# Norfolk Boreas Offshore Wind Farm Applicant's Comments on Deadline 6 Submissions and Other Submissions

Applicant: Norfolk Boreas Limited  
Document Reference: ExA.ASR.D7.V1  
Deadline 7

Date: March 2020  
Revision: Version 1  
Author: Royal HaskoningDHV

CAWSTON HIGH STREET - INTERVENTION SCHEME  
Scale 1:500

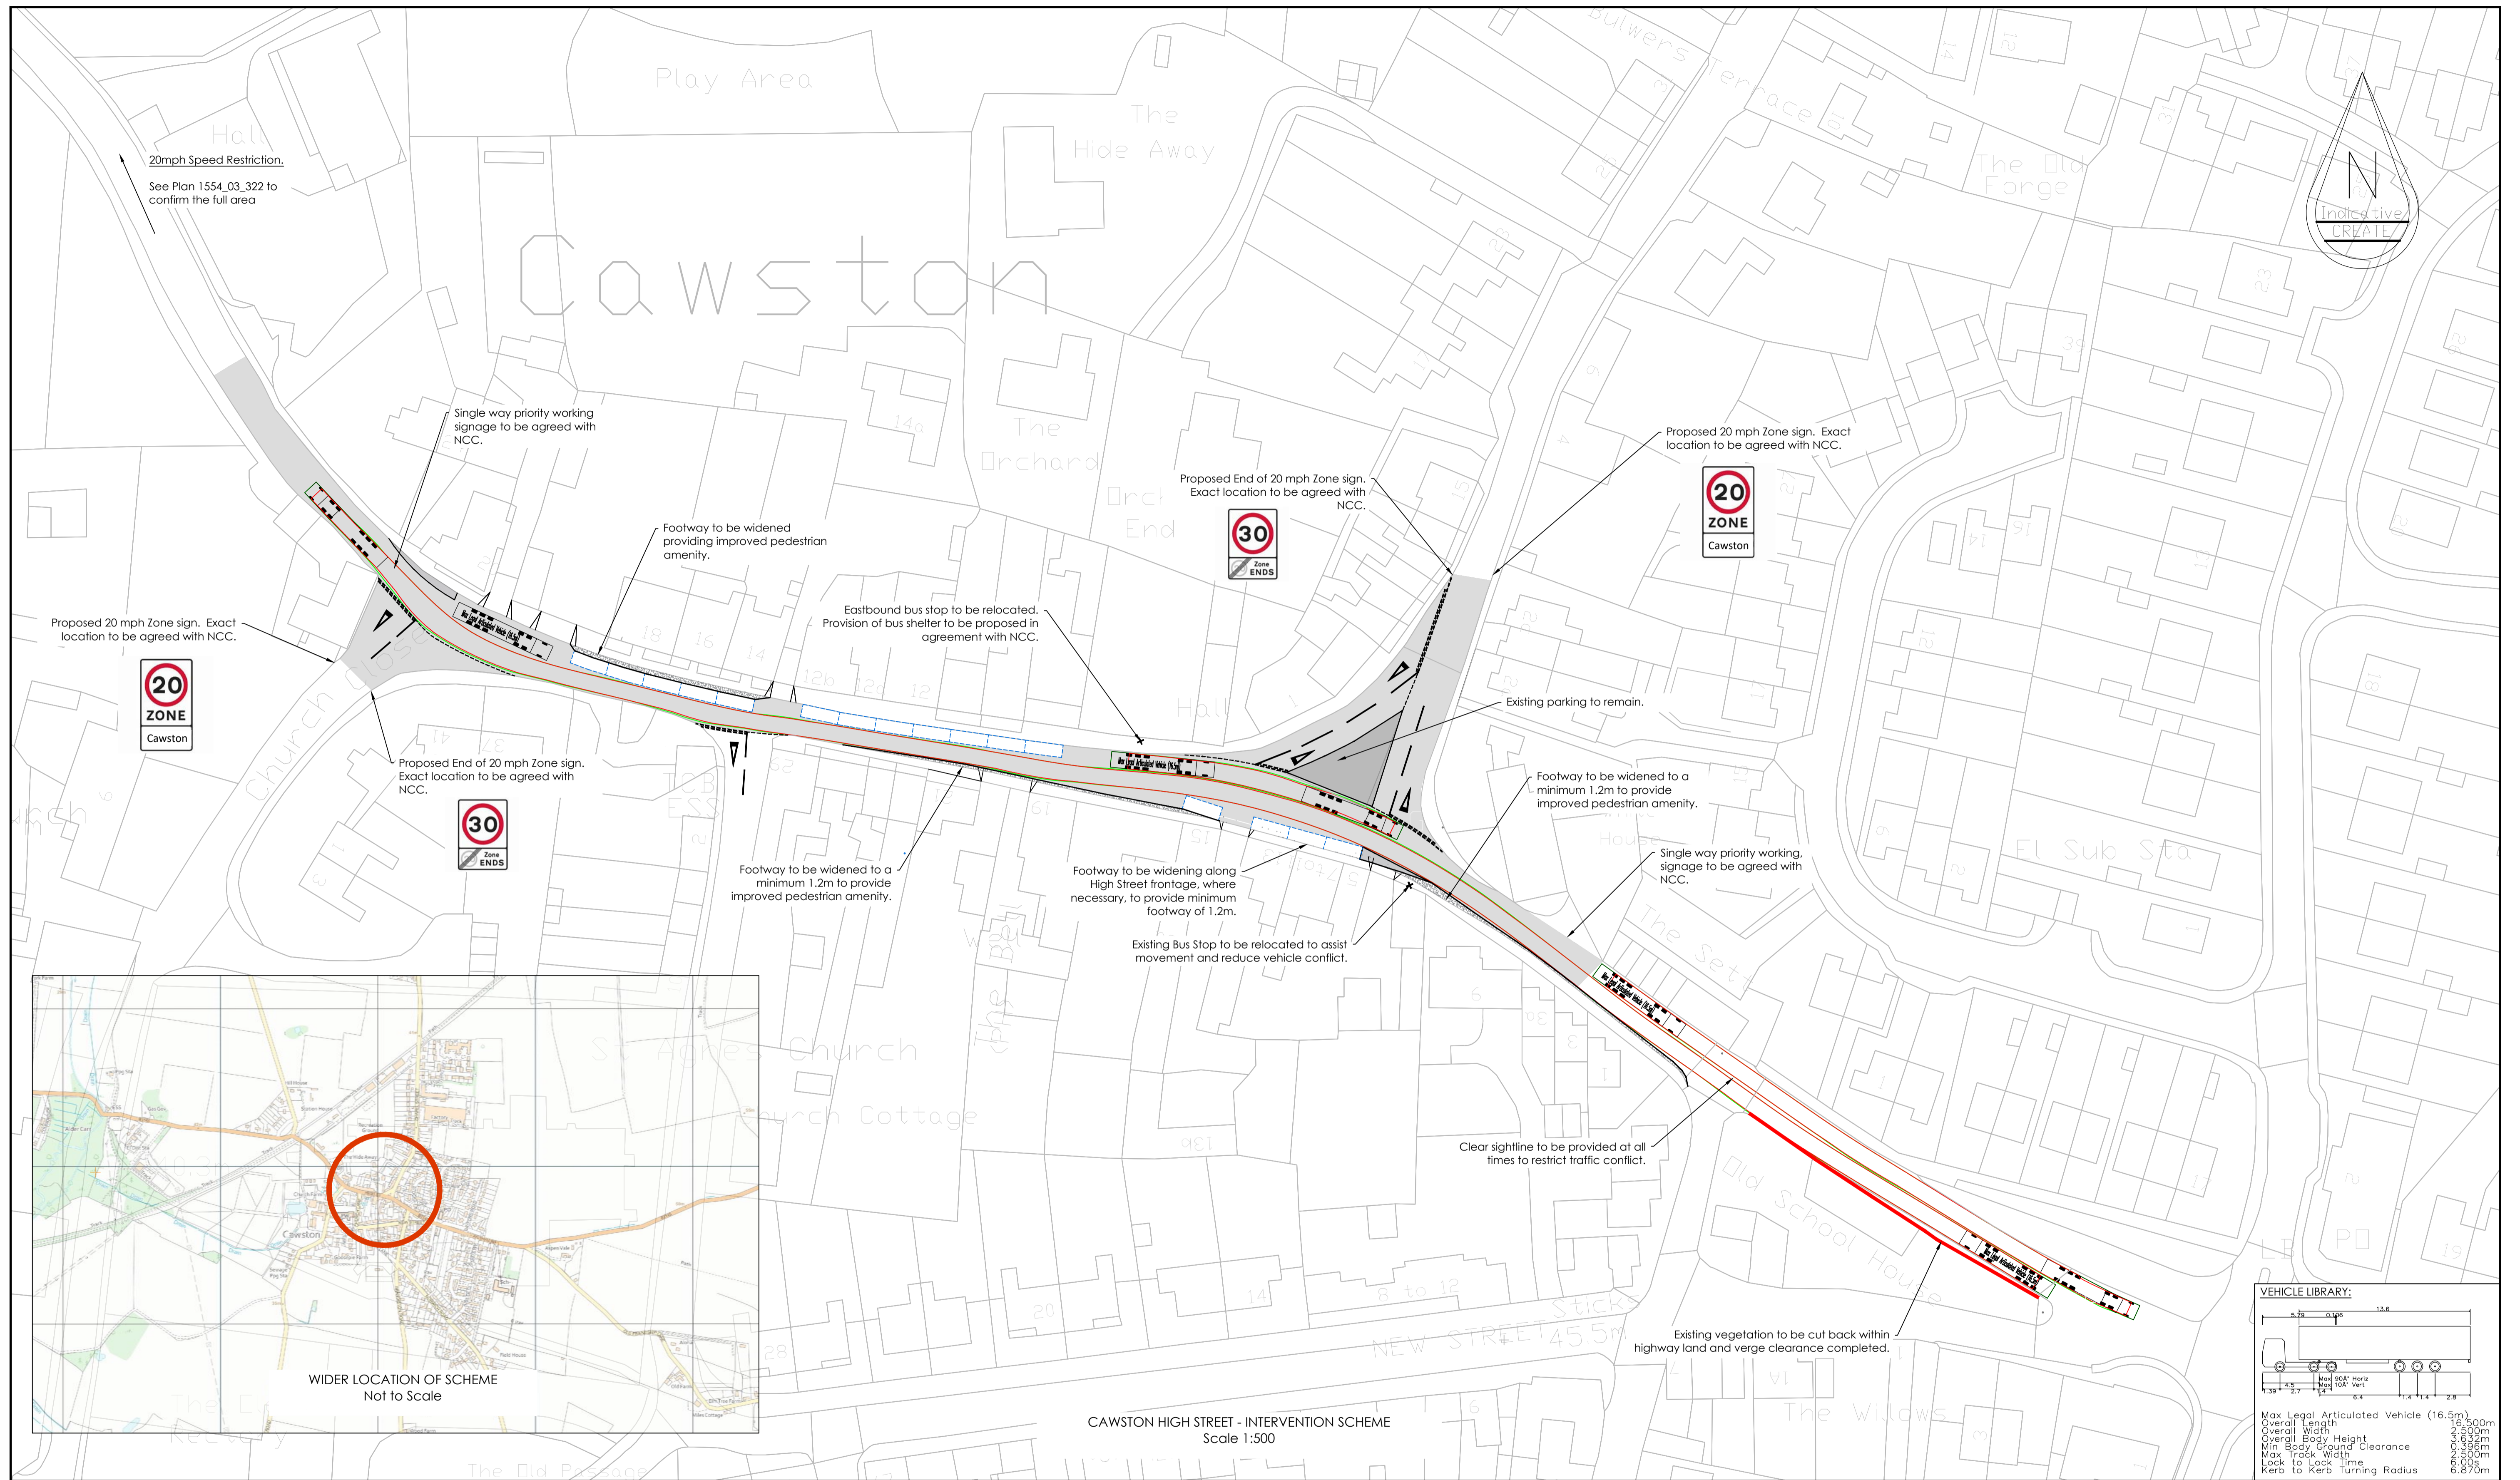
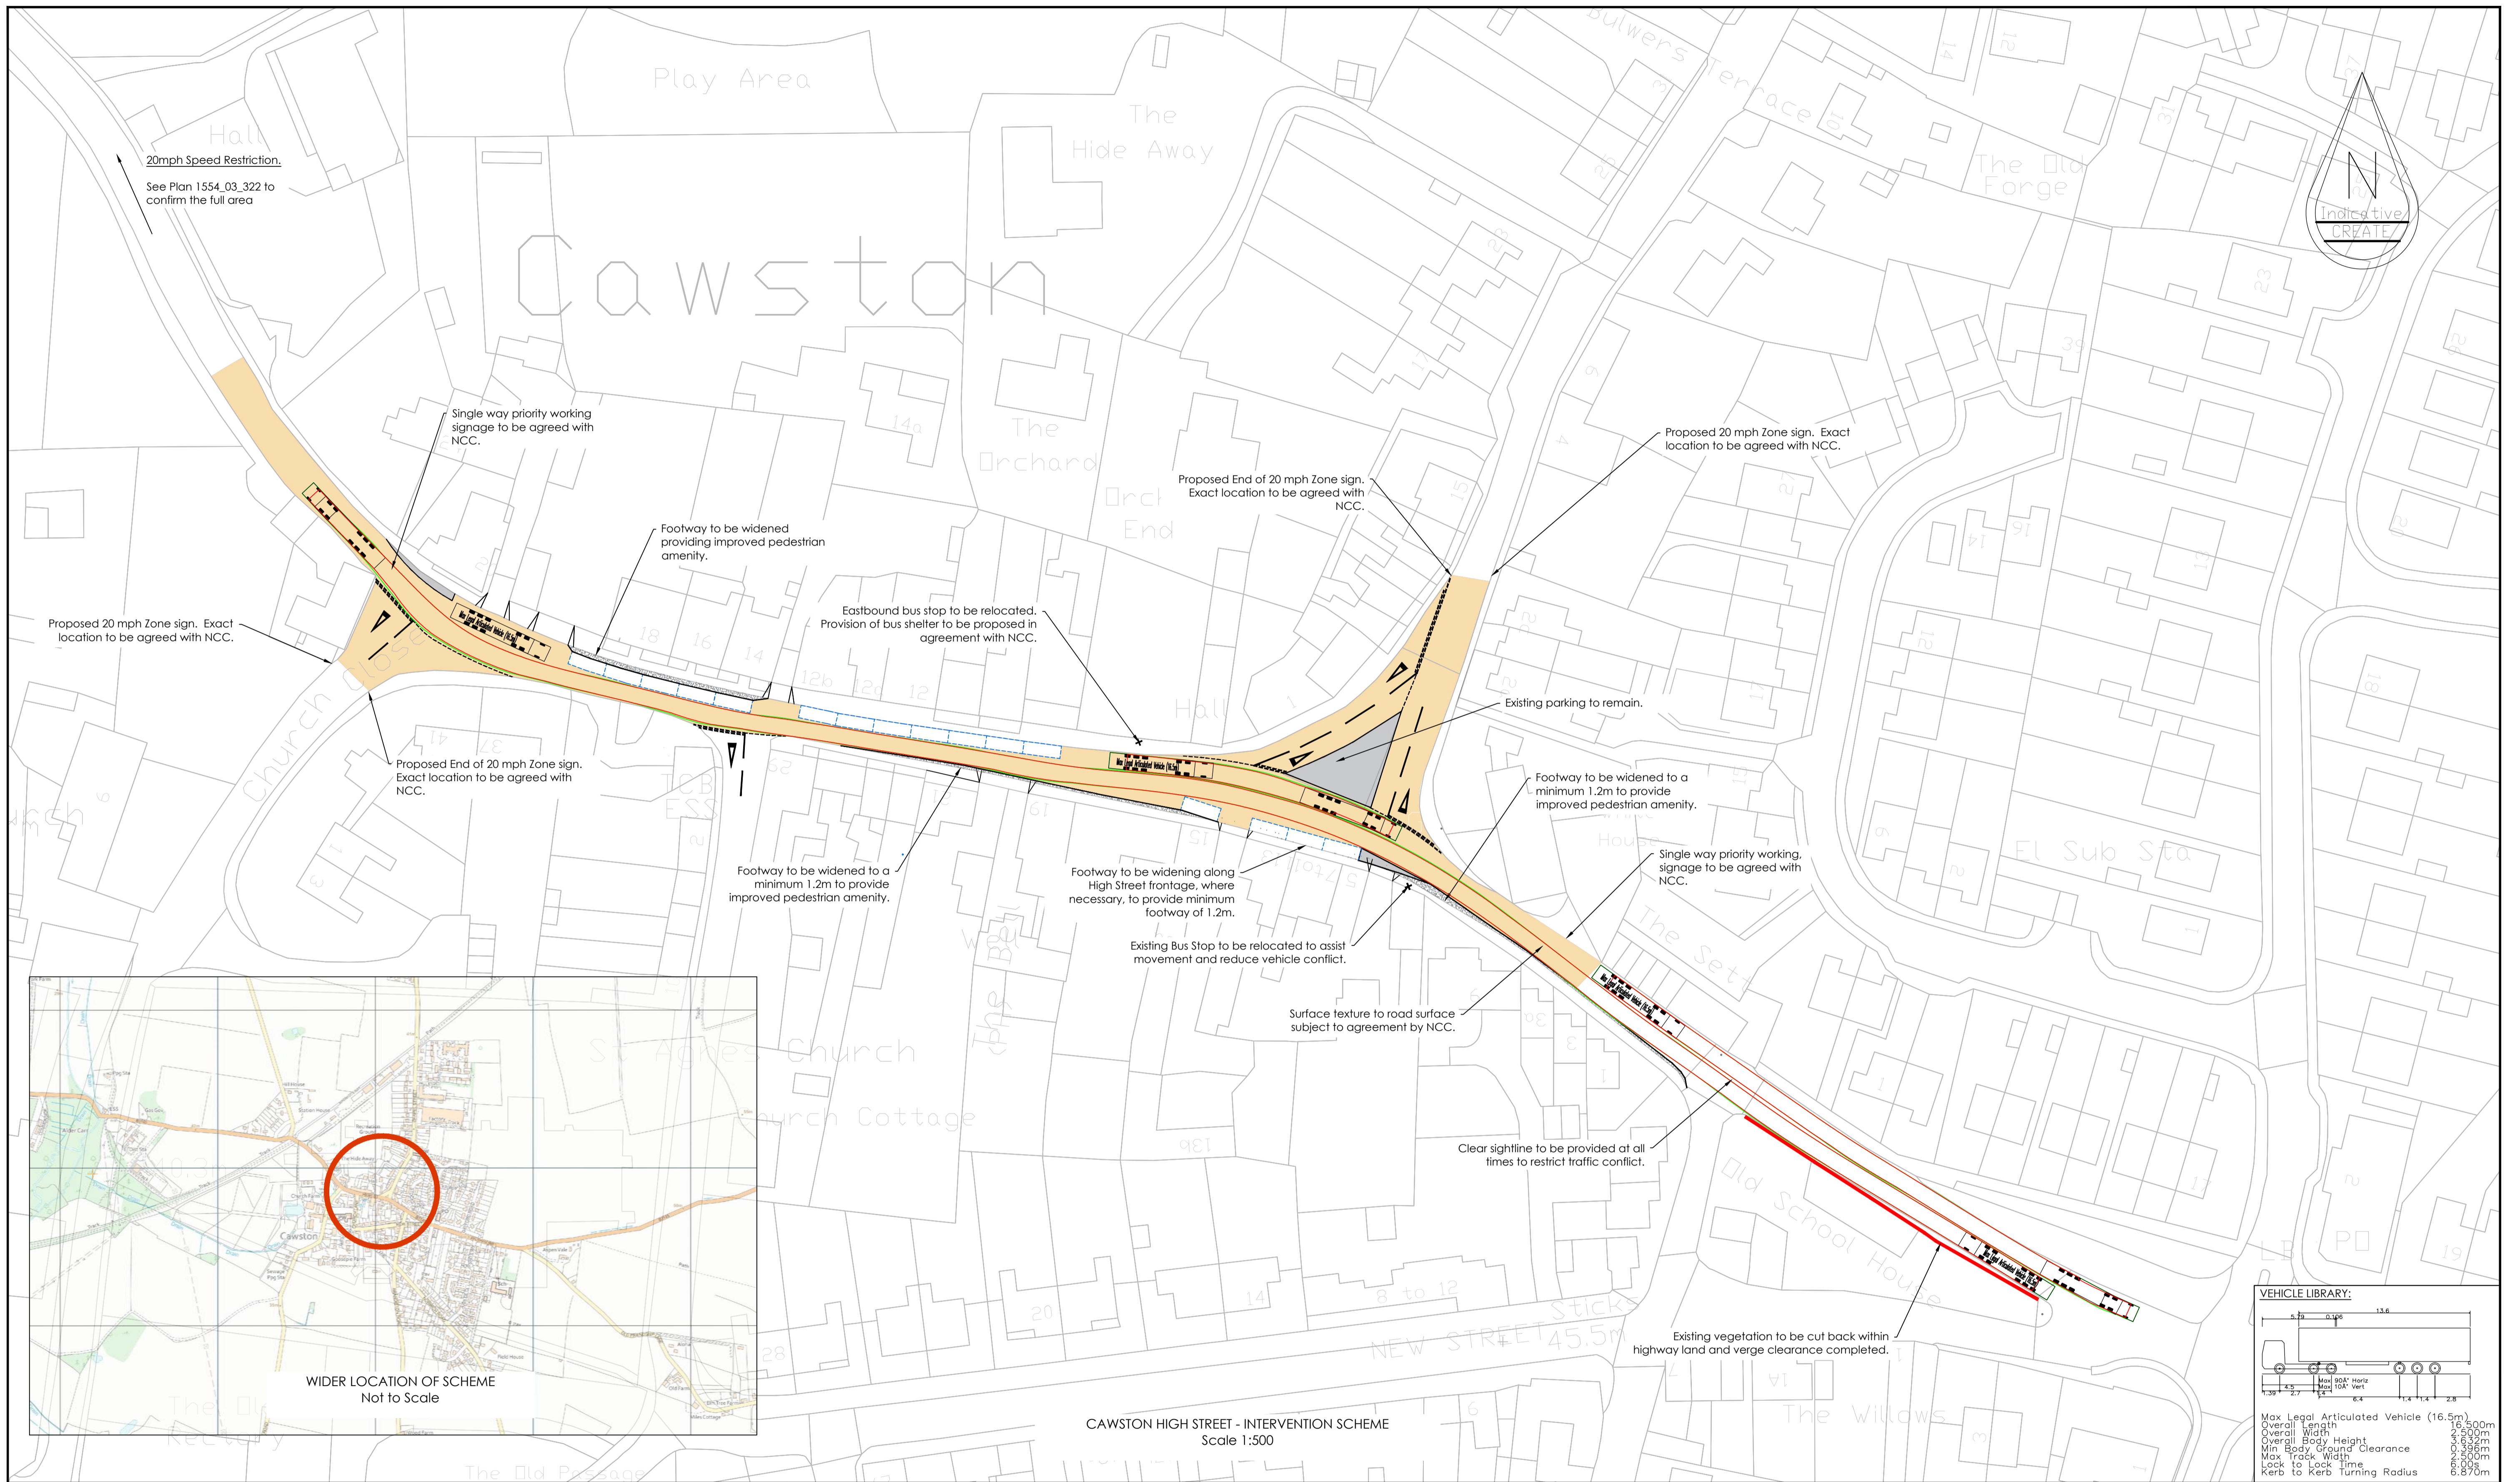
<p><b>Cumulative Traffic Effects in Cawston</b></p>	
<p>Our Deadline 5 submission expressed our doubts about the revised Highway Intervention Scheme. Now that we have had the chance to see the Road Safety Audit we would add the following:-</p> <p>a) The RSA confirms our points about dangers arising from sending this traffic through the centre of the village, due to the narrow road and pavements.</p> <p>b) The brief given to the auditors only includes Boreas traffic numbers. We suggest that the cumulative numbers of H3 and Vanguard/Boreas together might well have caused the auditors to be more emphatic in their conclusions.</p>	<p>a) The road safety audit process is to identify aspects of engineering interventions that could give rise to road safety problems and to suggest modifications that could improve road safety for all users. In doing so, the RSA makes recommendations to address any problems identified.</p> <p>The Applicant has addressed all the recommendations made in the RSA in the revised HIS designs submitted at Deadline 5 [REP5-027].</p> <p>NCC indicated during a meeting on the 16<sup>th</sup> March 2020 that no further amendments are required to the HIS and there are no remaining technical</p>

Summary of Submission	Applicant's Comments
<p>c) In their comments on the RSA the Applicant sets out a summarised baseline position in Appendix C. We have asked the Applicant for more details but had received no response at the time of writing.</p> <p>d) At a meeting last year with Norfolk Vanguard, they mentioned that they understood that Hornsea 3 defined all vehicles above 3.5 tonnes as "HGV" in their figures.</p> <p>e) If this is the case, then surely it is not consistent and reasonable to compare these numbers directly with the additional traffic, all of which will be larger vehicles.</p> <p>f) Para 26 Table 1 in the RSA commentary quotes different (lower) HGV numbers from those previously reported in REP3-003. We also await the Applicant's comments on this.</p> <p>g) The latest figures from the Applicant will bring one additional (large) HGV every two minutes, apparently with metronomic timing on a "just in time" schedule.</p> <p>h) Walking at 4km per hour (2.5 mph) a pedestrian covers 133 metres in two minutes. This means that every pedestrian can expect to encounter at least one of the Applicant's HGVs as they walk through the village.</p> <p>i) The RSA states "However, even with these points in mind, the Audit Team still perceive there to be a risk to pedestrians due to the narrowness of the footway and the proximity that HGVs will be to pedestrians."</p> <p>j) Cawston Parish Council suggests that historical collision figures have no value in determining the additional risk of collision from the applicant's construction traffic in our village. The nature of collision risk in Cawston is entirely changed by routing large volumes of HGV and other traffic on the B1145 through the village.</p> <p>The RSA auditors state that "Without full collision data the Audit Team cannot ascertain the causation factors for these collisions. When considering the use of collision data".</p>	<p>objections. Accordingly, NCC also indicated they will be completing the RSA log to finalise the scheme.</p> <p>b) The brief submitted to the independent Road Safety Auditors included the Technical Note: Revised Cawston Highway Intervention [REP4- 016] which provided the background and supplementary information on the scheme and detailed (para. 2) a cumulative HGV figure of 239 movements (which includes HP3 with Norfolk Boreas Scenario 2 or Norfolk Vanguard).</p> <p>NCC have confirmed the RSA is valid and submitted the document to the Development Control panel for review.</p> <p>The Applicant has addressed all the recommendations made in the RSA. Since a meeting held between the Applicant and NCC on the 16<sup>th</sup> March 2020, it is the Applicants understanding that no further amendments are required to the HIS and there are no remaining technical objections. Accordingly, NCC also indicated they will be completing the RSA log to finalise the scheme.</p> <p>c) The Applicant responded to Cawston Parish Council's additional queries on the 10<sup>th</sup> March 2020. The responses are provided below:</p> <p><i>CPC Query 1: Table C1 -We have searched the H3 document but can't find the specific numbers you quote. Could you point us to them, or how they were arrived at?</i></p> <p><u>Applicant's Response to CPC 10<sup>th</sup> March 2020</u>  <i>Table C1 is a direct replica of Table 2.1: Summary of Traffic Flows along B1145 through Cawston contained within the Hornsea Project Three (HP3) Document High Street Cawston –Highway Intervention Scheme – March 2019.</i></p> <p><i>The data in Table 2.1 (Table C1) has been extrapolated from the RAW ATC Traffic counts provided in Annex E from the HP3, Appendix 26 to</i></p>
